Addendum No. 1

RE: Contract # C203789

Pender County (B-4929)

Bridge #16 Over The Intracoastal Waterway On NC-50/210 At Surf City

Drawing file: 280 Utility Construction Plans / 280_036_B4929_ut_rdy4_UC09_psh.pdf

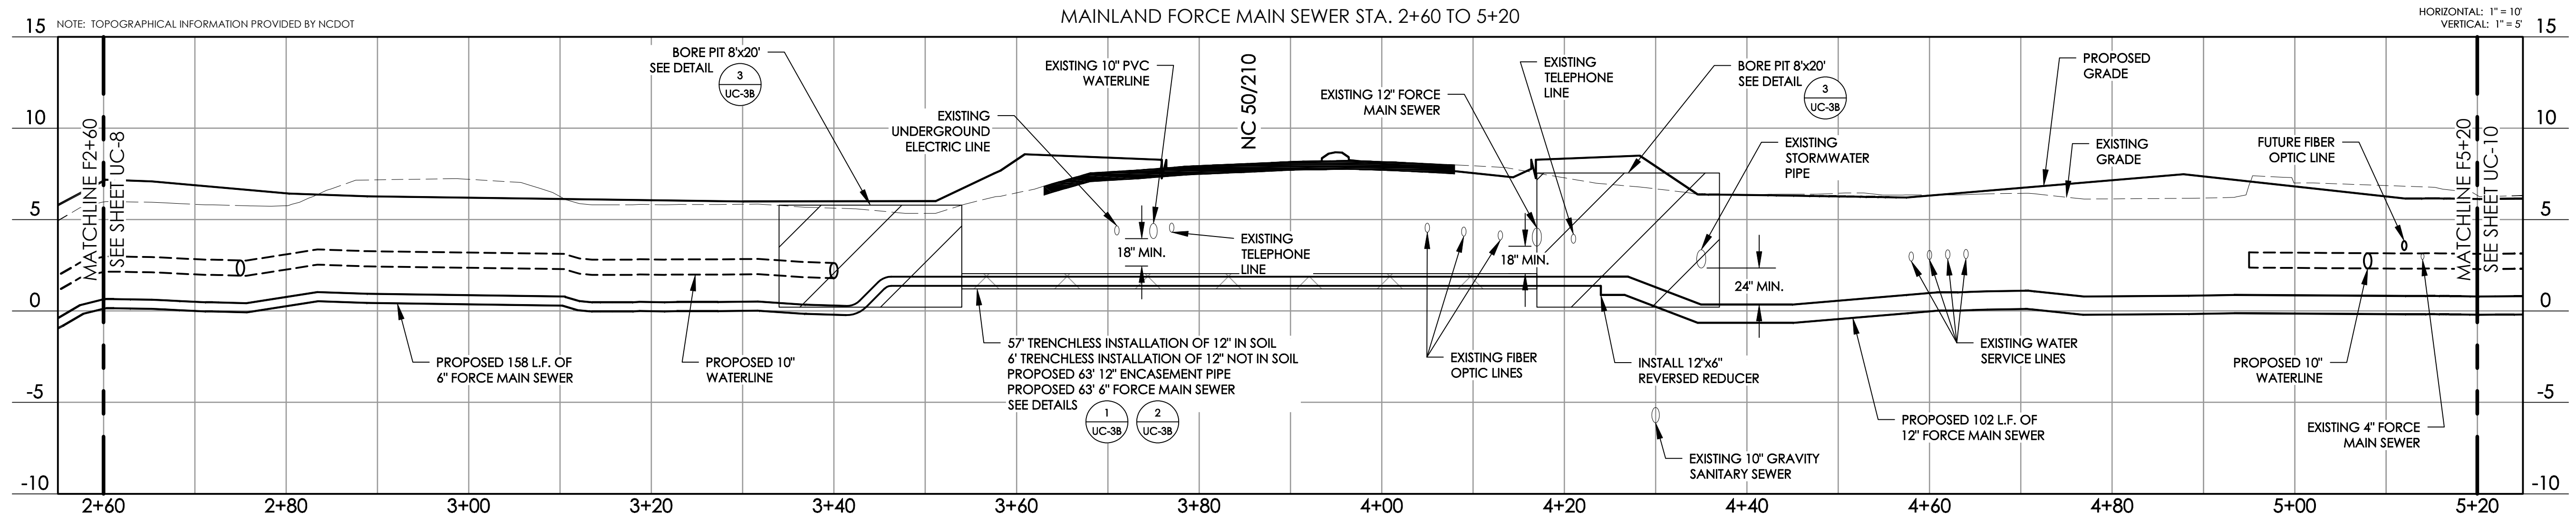
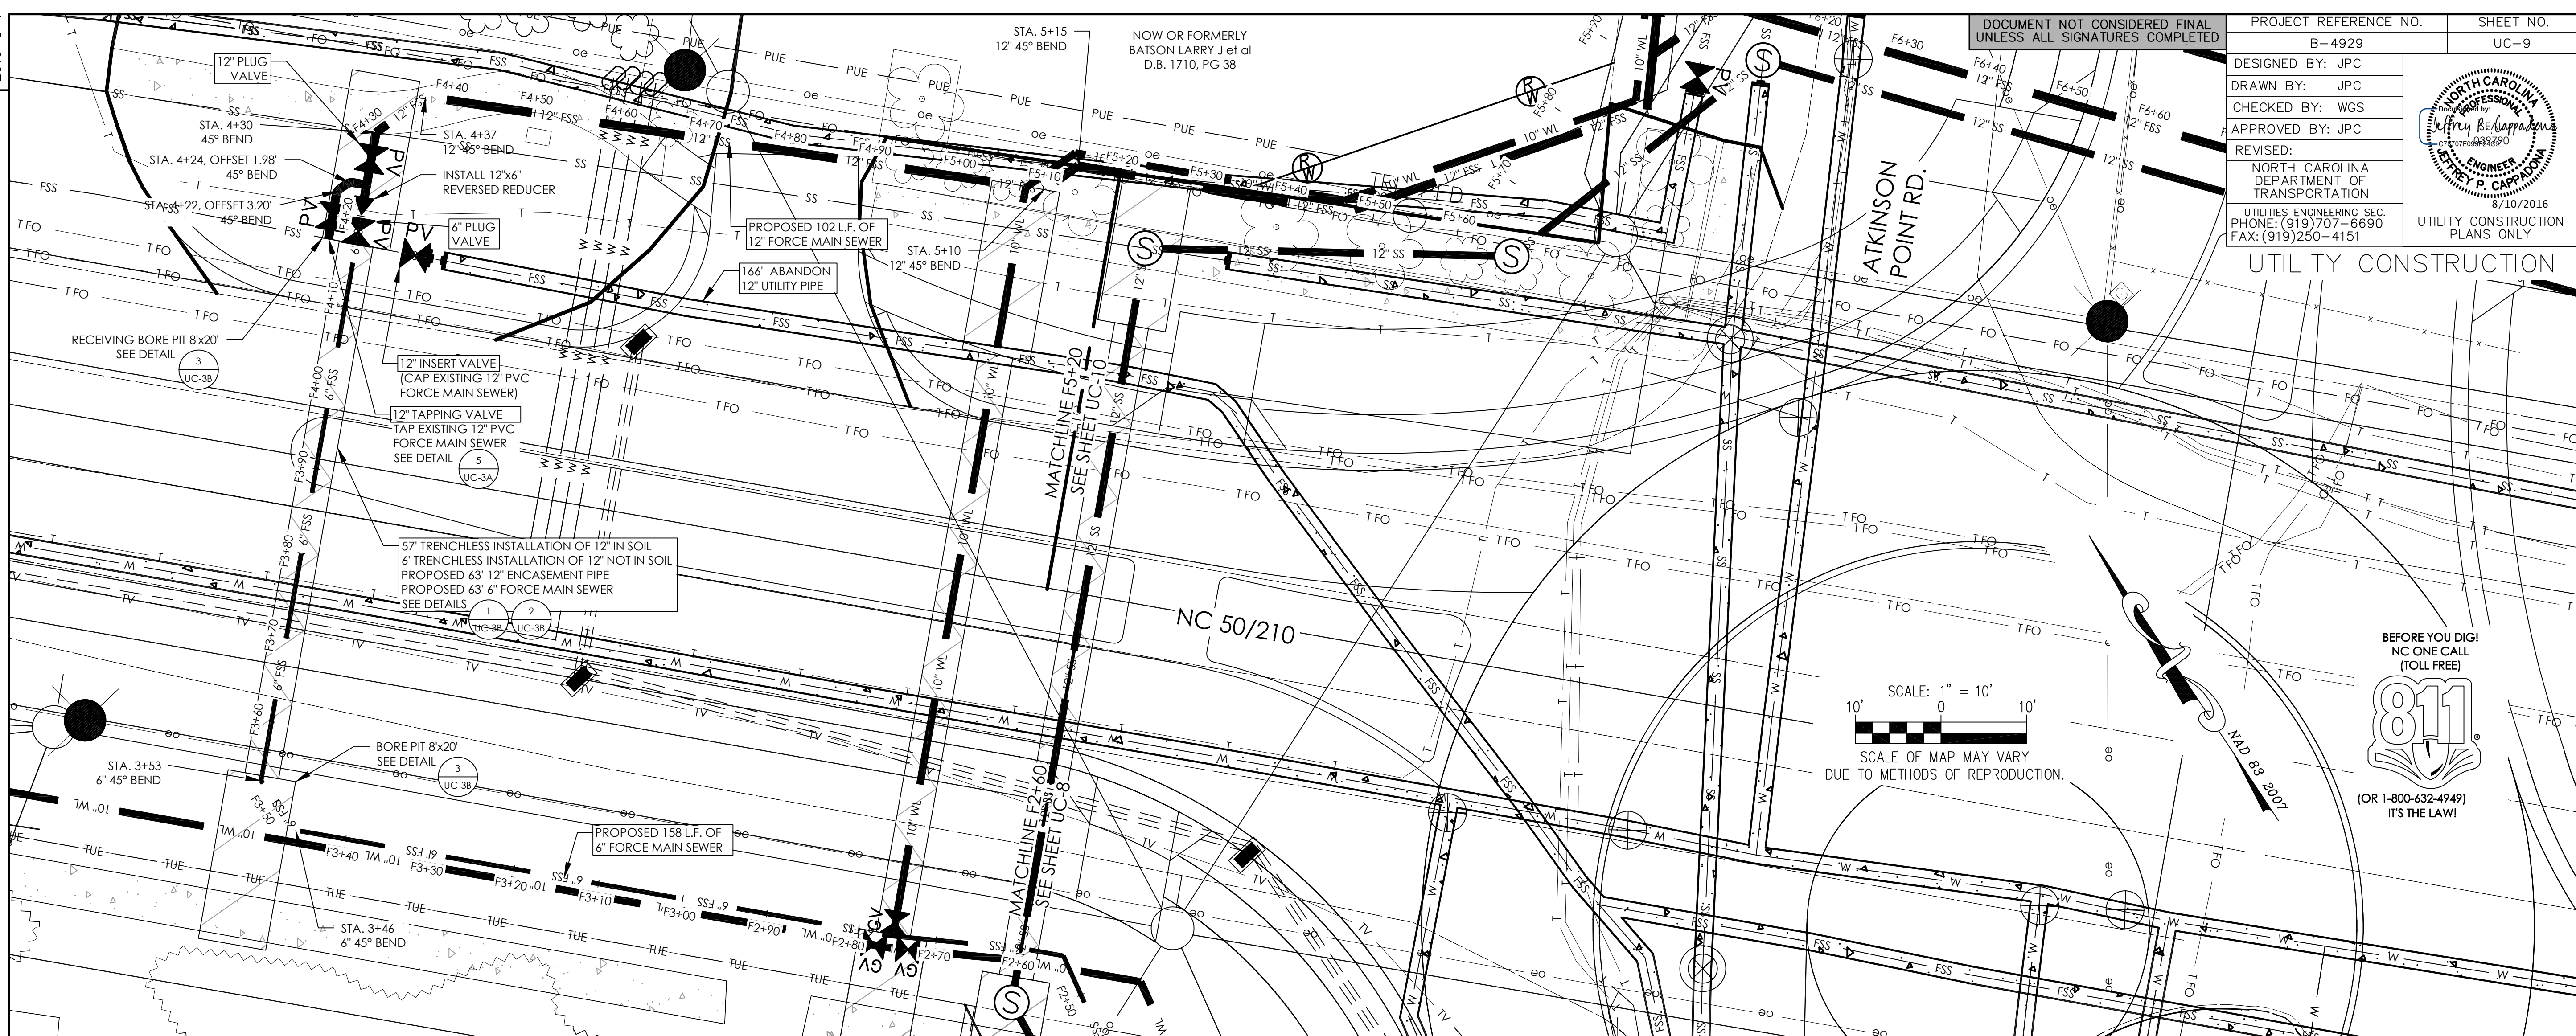
| Sheet No. | Revisions |
|-----------------|--|
| UC-9 | Note revised to add "12" Tapping Valve" |

Drawing file: 280 Utility Construction Plans / 280_051_B4929_ut_rdy4_UC14_psh.pdf

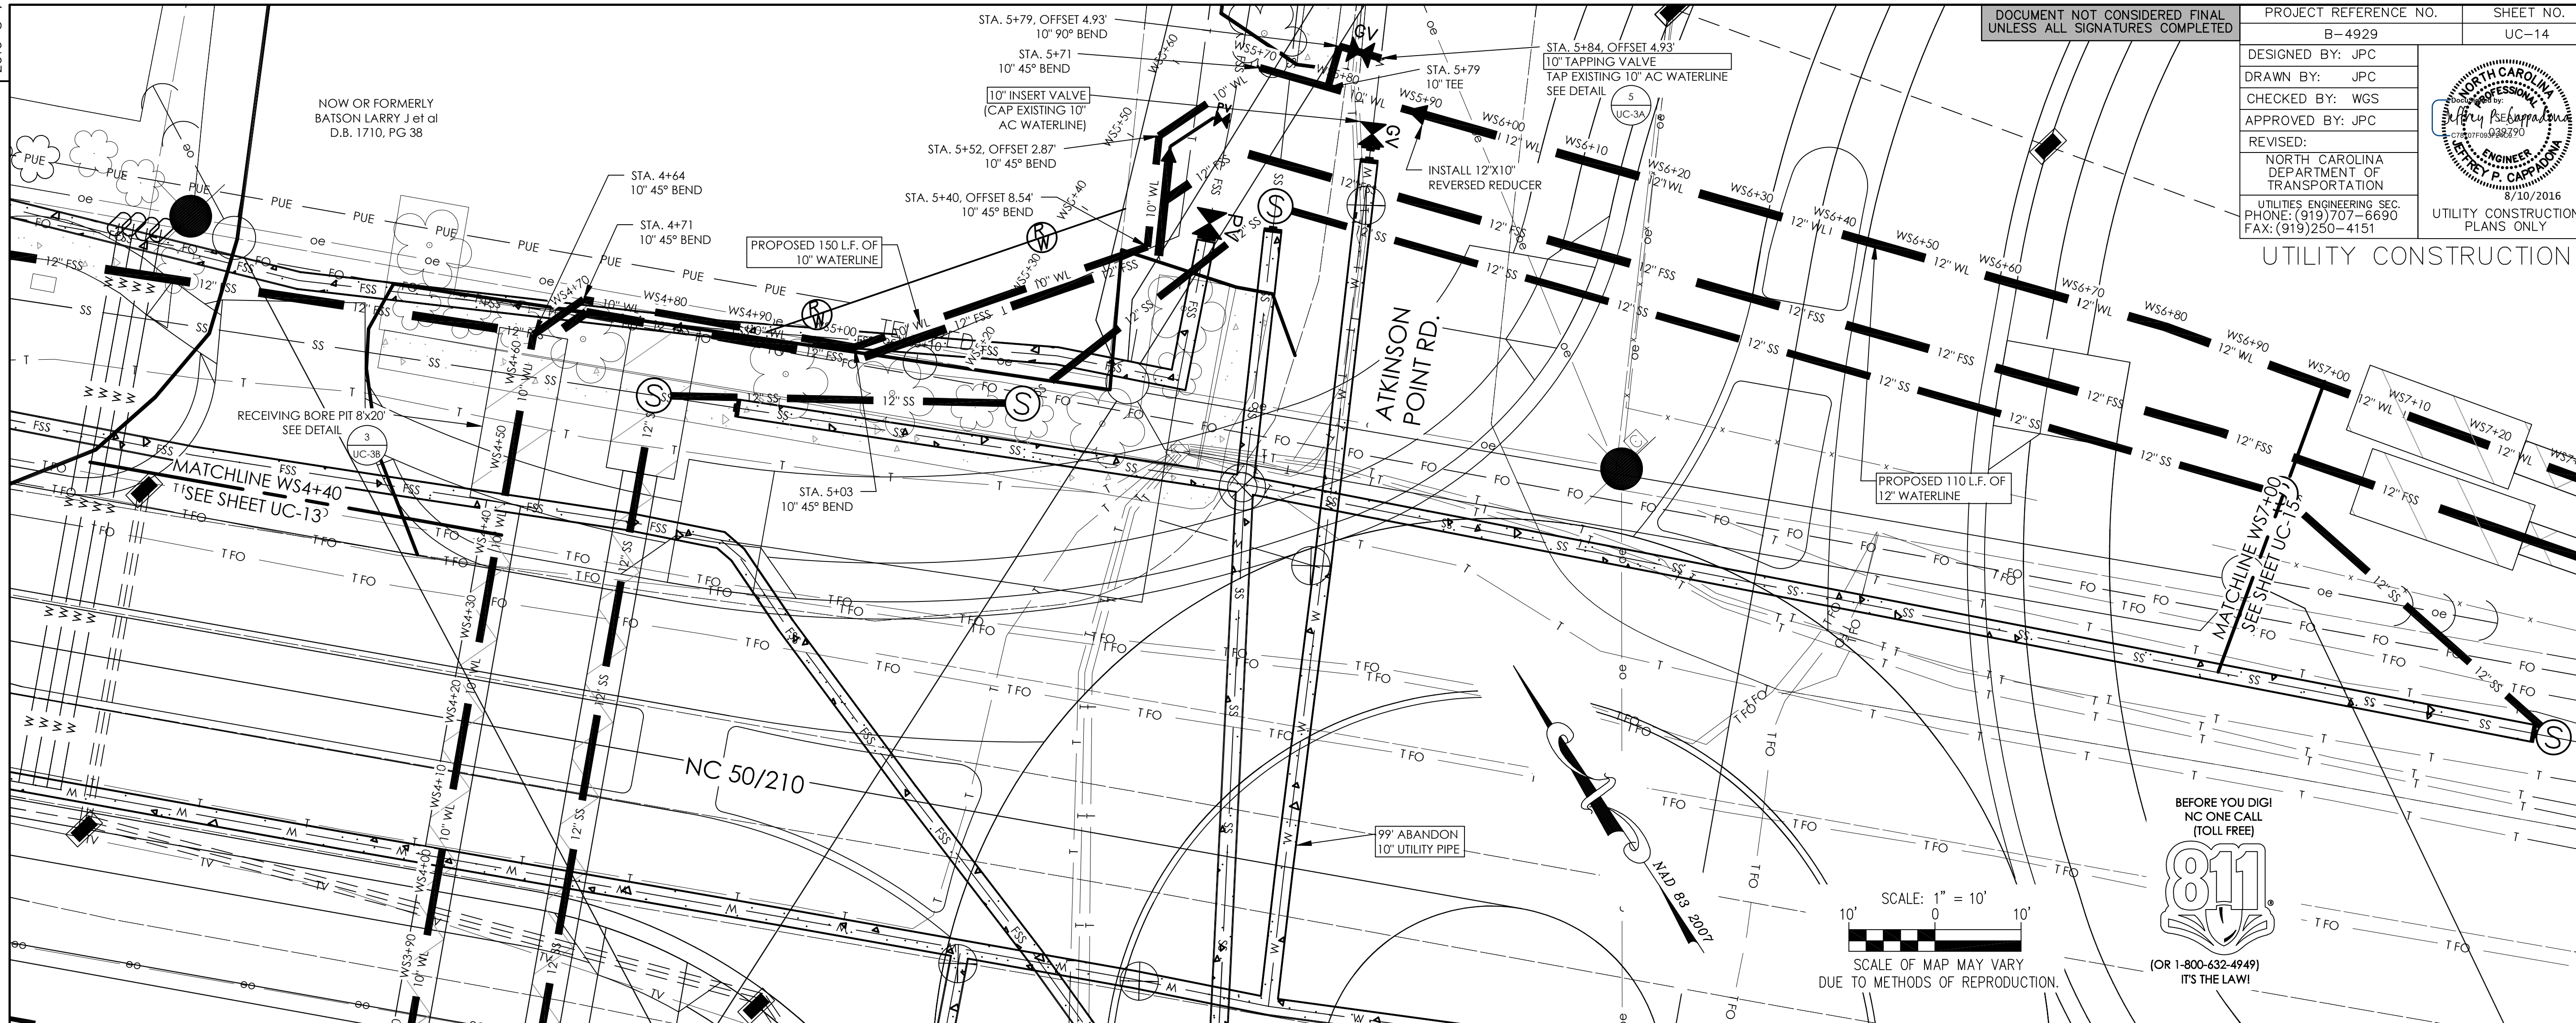
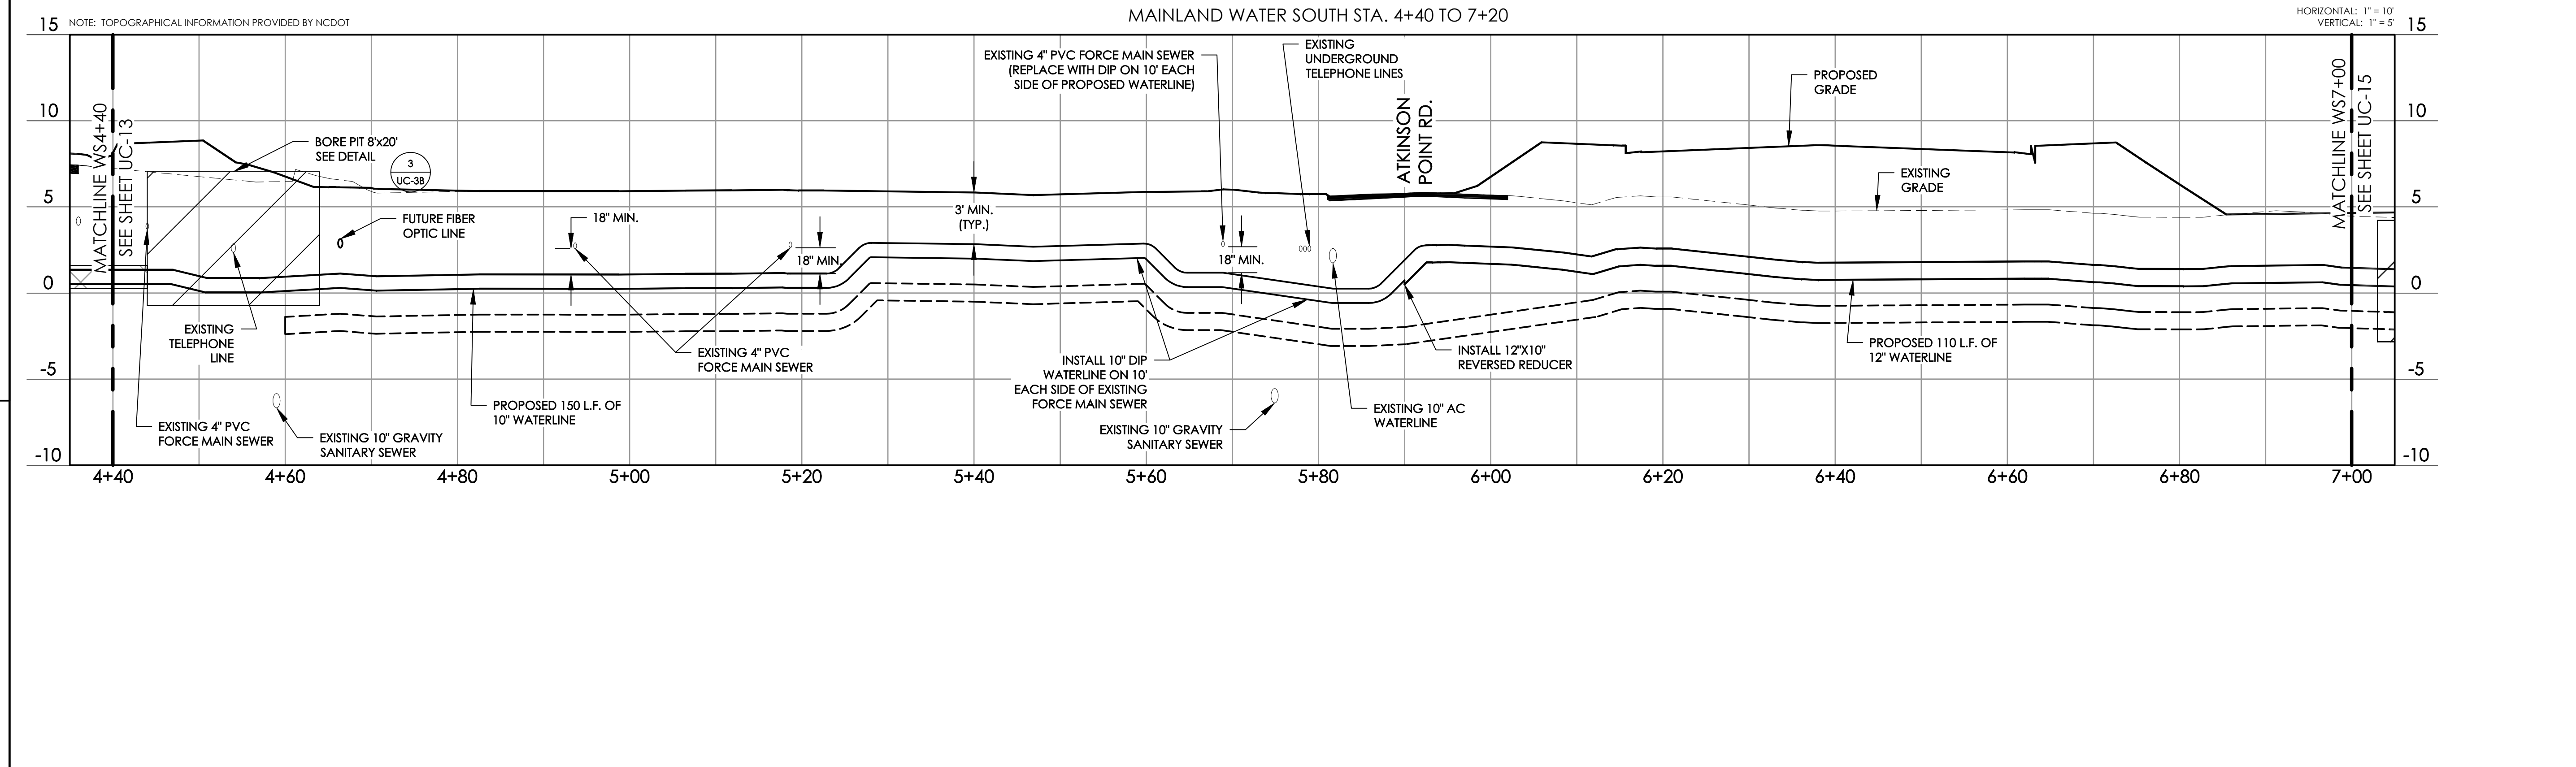
| Sheet No. | Revisions |
|-----------------|--|
| UC-14 | Note revised to add "10" Tapping Valve" |
